DELEGATED DECISION

Item No.	Report of the Head of Development Management and Building Control	
Address:	1 ALPHA ROAD HILLINGDON	
Development:	Demolition of existing bungalow and erection of 1x 3 bedroom two-storey dwellinghouses and 2x 1 bedroom two-storey dwellinghouses, with associated landscaping and parking provision.	
LBH Ref Nos:	41903/APP/2024/2570	
Drawing Nos:	Location Plan 0432-PLA-01-A 0432-PLA-02-A 0432-PLA-50-B 0432-PLA-51-B 0432-PLA-52-B 0432-PLA-53-B 0432-PLA-54-B 0432-PLA-55-B 0432-PLA-56-B 0432-PLA-57-B 0432-PLA-58-B 0432-PLA-59-A 0432-PLA-60-A 0432-PLA-61-A 0432-PLA-62-A 0432-PLA-63-A 0432-PLA-70-A Design and Access Statement, September 2024, Michael Oakes Architects Transport Statement, September 2024, Michael Oakes Architects	
Date Plans received:	25-09-24	Date(s) of Amendments(s):
Date Application valid	25-09-24

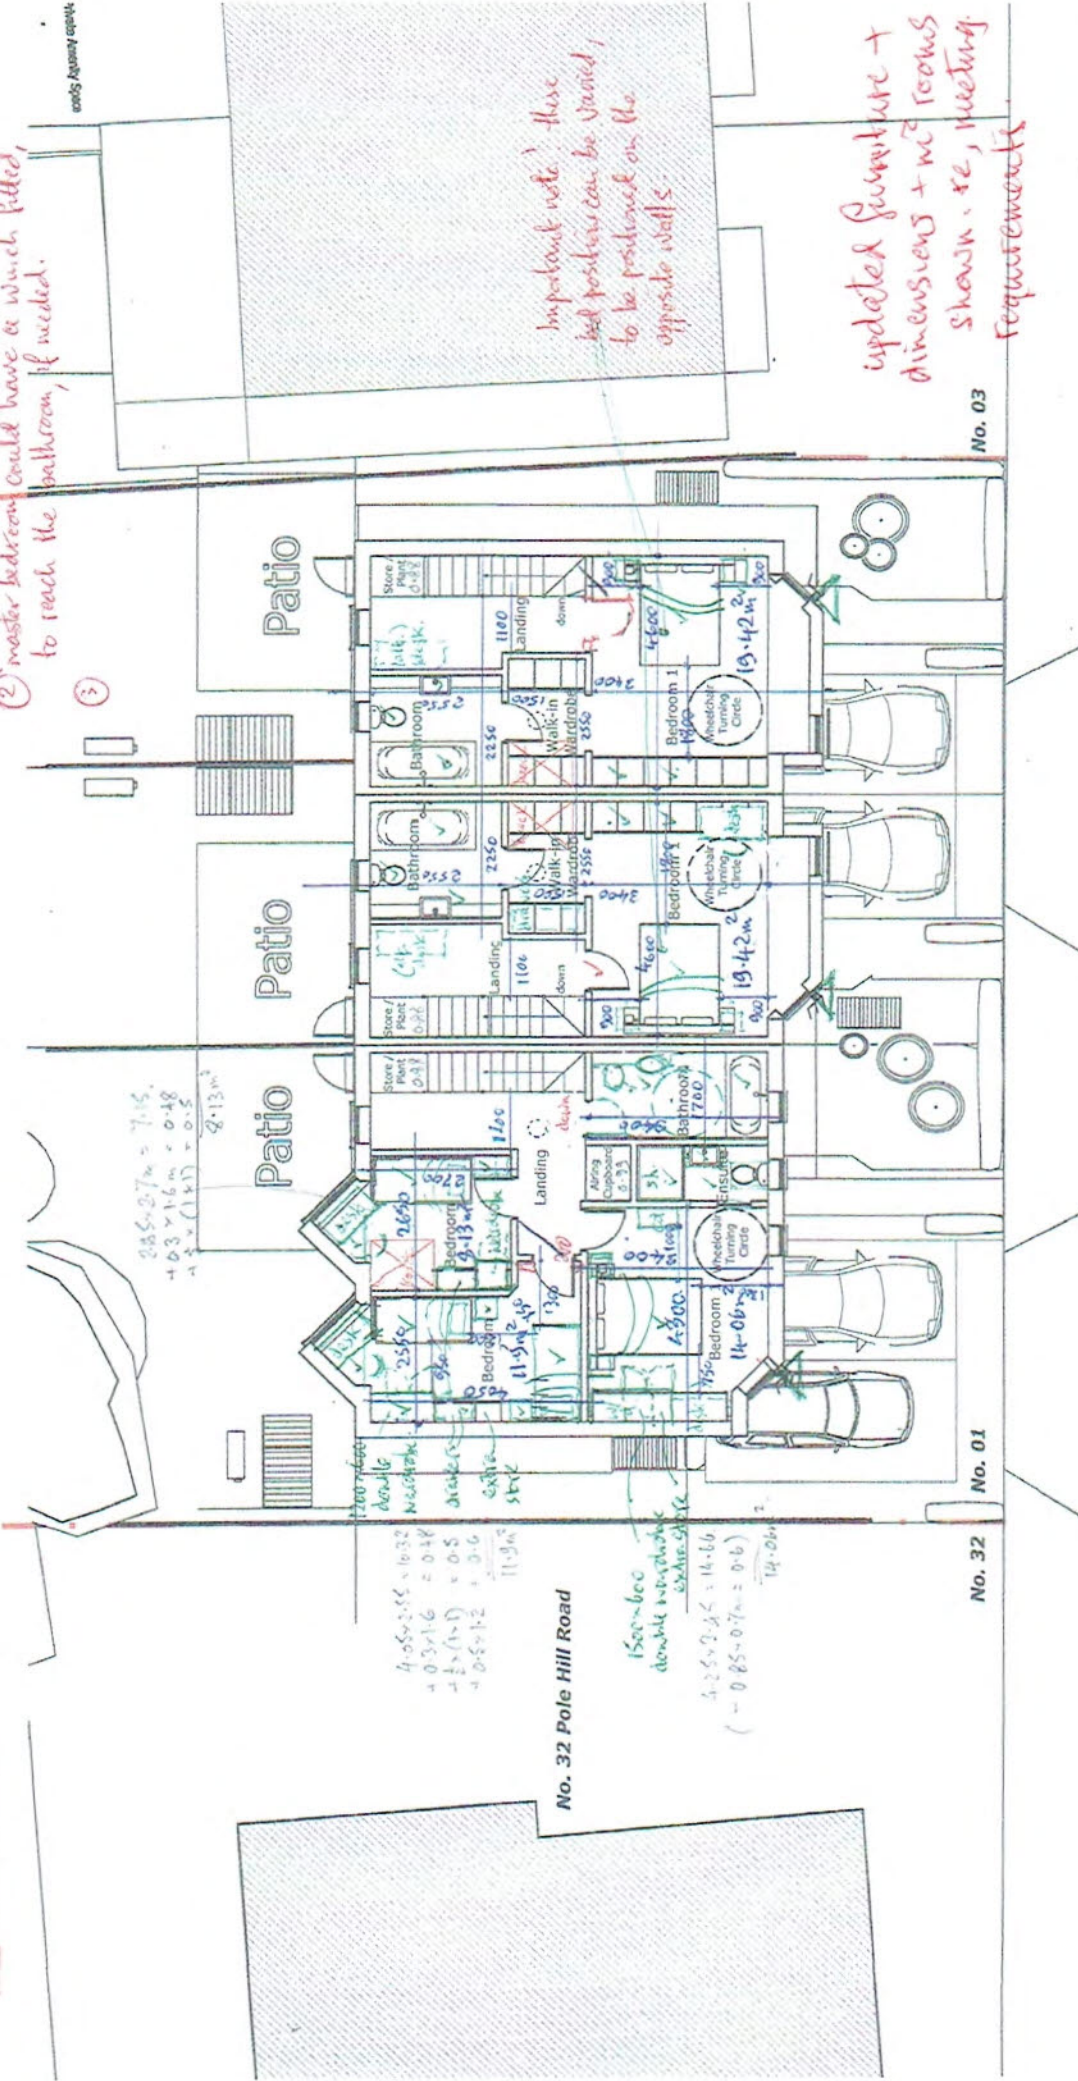
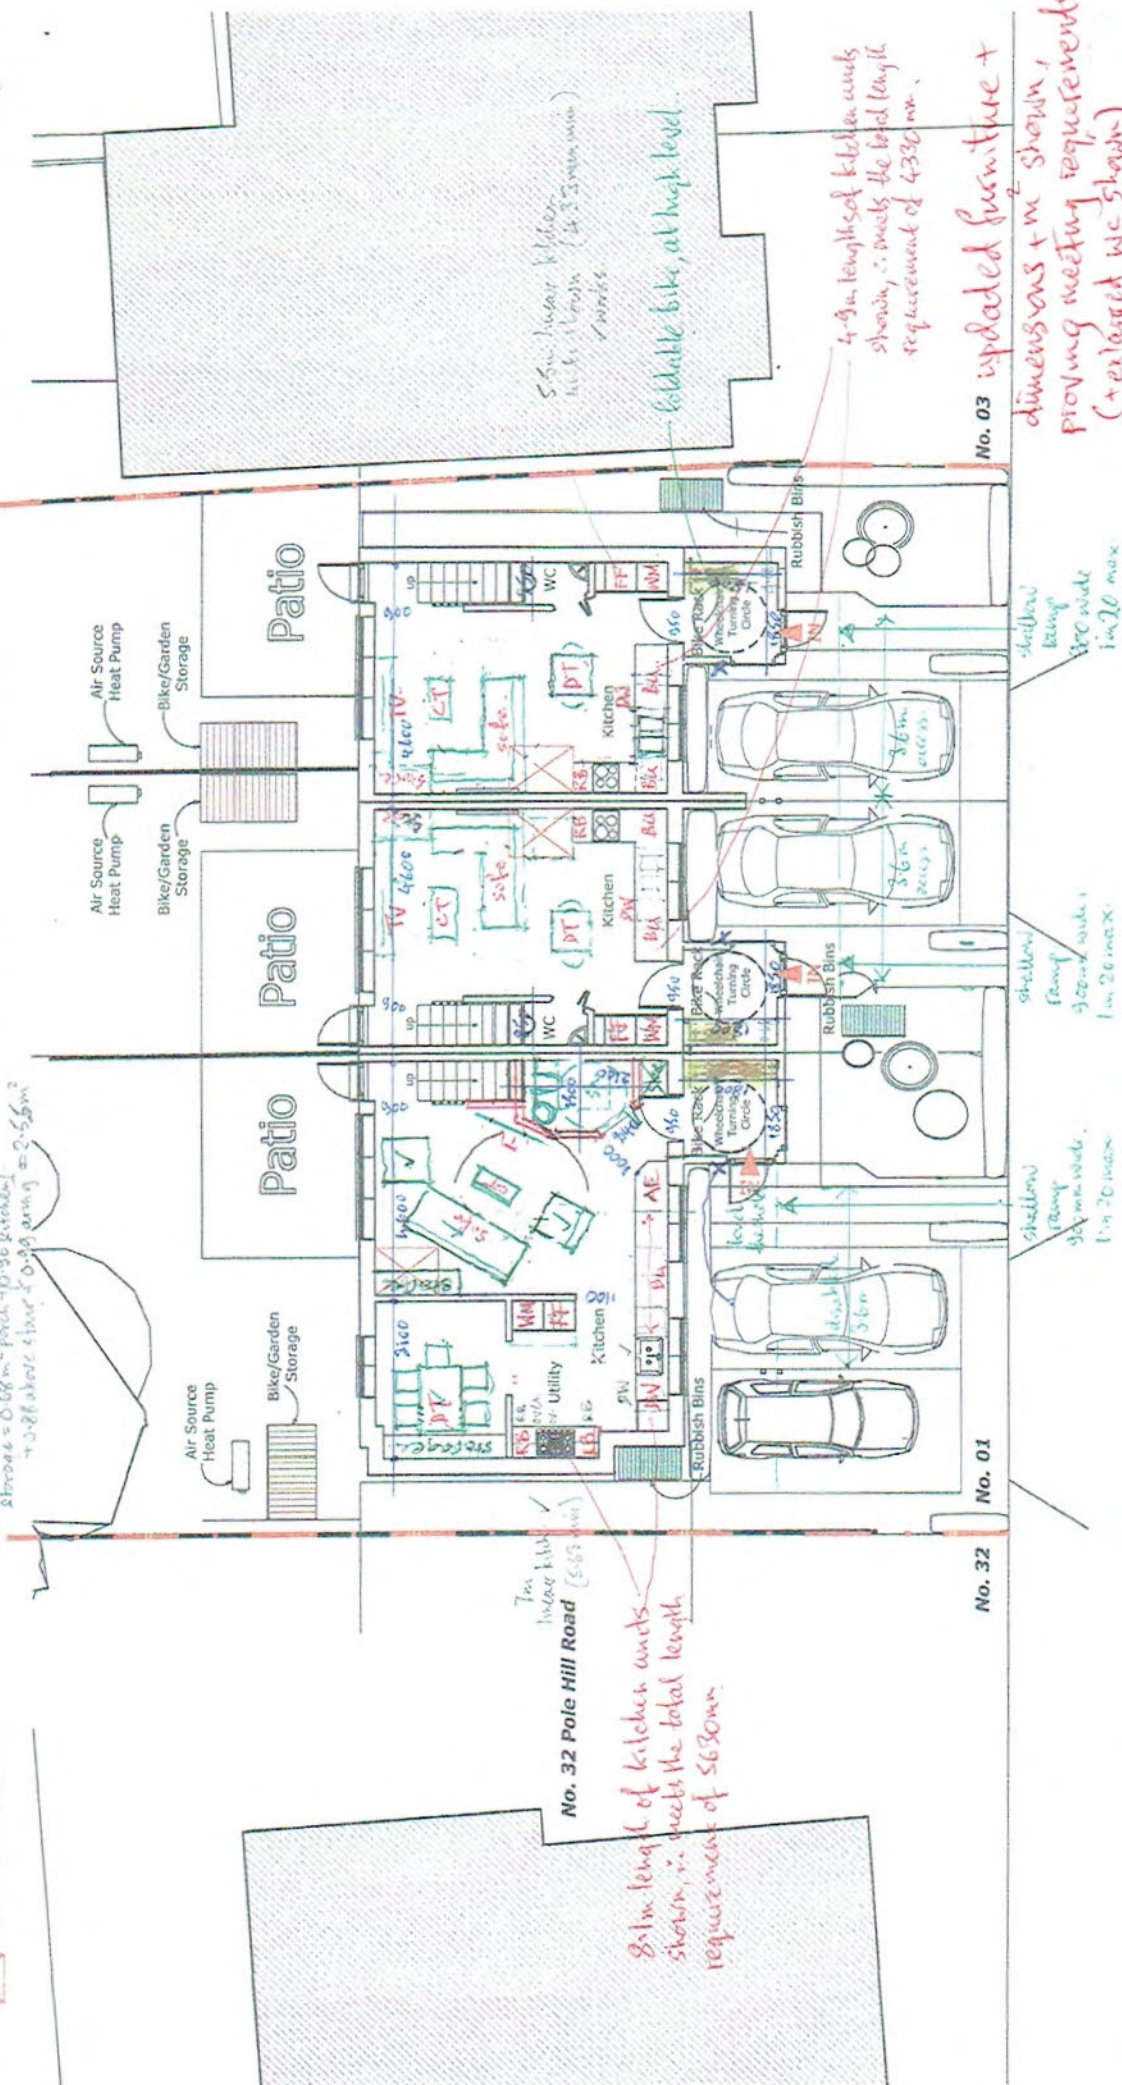
The proposed layout fails to demonstrate that it would be designed and constructed as an accessible and adaptable dwelling in accordance with M4(2) technical specifications as set out in Approved Document M to the Building Regulations (2015 edition). As such the proposed development is contrary to Policy D7 of the London Plan (2021).

In regard to the above, the proposed drawings fail to accord with the minimum required accessible living standards. Step free access is not illustrated, the entrance level W/C in the three bed unit is too small and fails to achieve the required clear access zones set out in section 2.27(c) of Approved Document M, Volume 1 (2015 edition). The plans fail to demonstrate compliance with figure 2.6 as set out in Approved Document M to the Building Regulations, in particular the layout of the toilet pan, hand basin, and level access shower fail to satisfy the 2021 London Plan policy D7. Furthermore the plans lack the detail required to demonstrate compliance with the M4(2) technical specifications (as relevant), set out in Approved Document M to the Building Regulations (2015 edition).
